From: Gary Alford [REDACTED]
Sent: 11 March 2022 15:51
To: Harry Chalk <Harry.Chalk@arun.gov.uk>
Subject: Re: FG/17/22/HH, 44a Ocean drive

From: Gary Alford <[REDACTED]>
Sent: 10 March 2022 16:12
To: Harry Chalk <Harry.Chalk@arun.gov.uk>
Subject: RE: FG/17/22/HH, 44a Ocean Drive

Subject: FG/17/22/HH, 44a Ocean Drive

SITE PLAN 1:500 @ A1

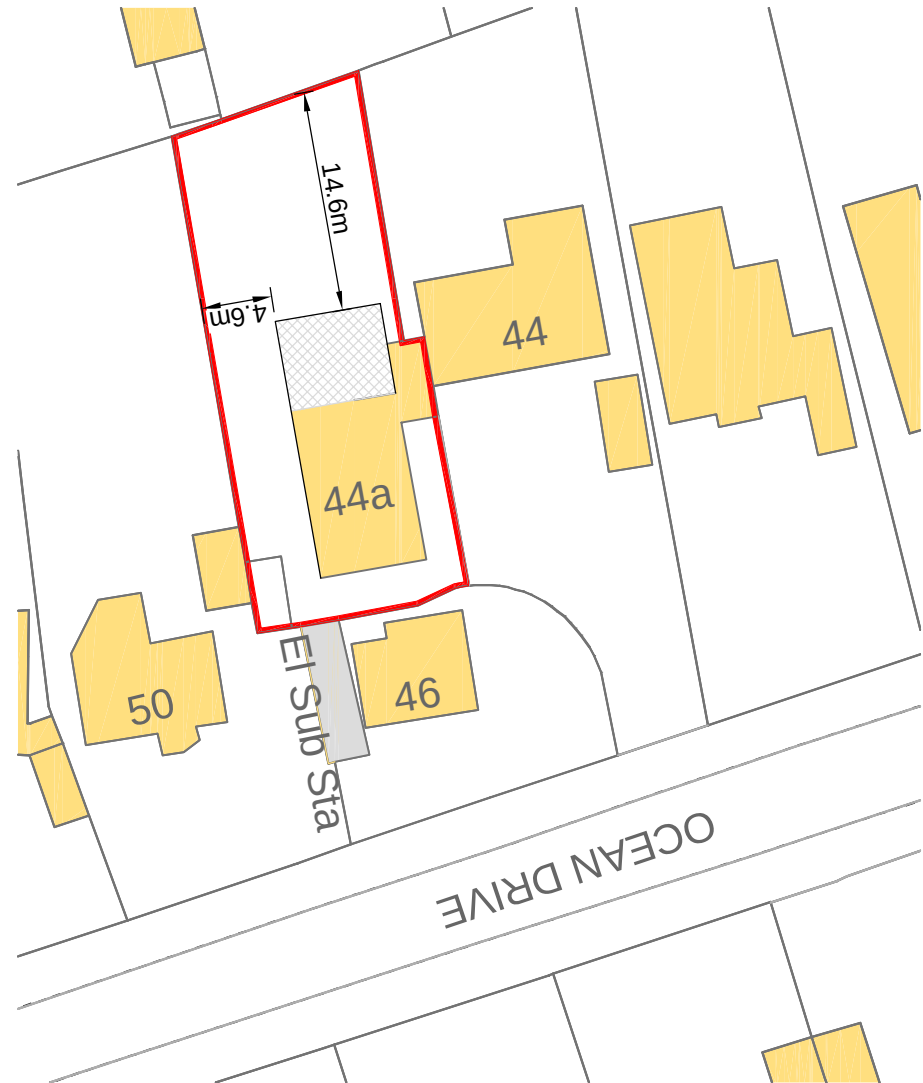
I recall you are to return to work as of today per our phone call a couple of weeks back. Thought it may be helpful to send over a reminder email as I know you are likely to be busy! Below I have forwarded the email I sent initially back on 18-02-22. Could I request that the revised site/ block plan is forwarded to me as soon as possible, so as to not incur any further delays.

Additionally, I note the objection that has been submitted by a neighbour regarding the curtilage displayed on the site plans. The legal certificate attached to the application form refers to all land within the curtilage of the site plans as being owned by the applicant. From my visit yesterday and this objection I do have concerns as to whether the site plans do accurately show the correct curtilage. Could you confirm whether or not the correct curtilage is shown on the site plans? If not, could I request the site plans be amended and submitted within the week? By **25/02/22**. Many thanks.

Hello Harry
Many thanks for the reminder
Please find attached the updated block plan.
And just to reiterate I am happy for the amended description of a rear/side extension to be used on the application.
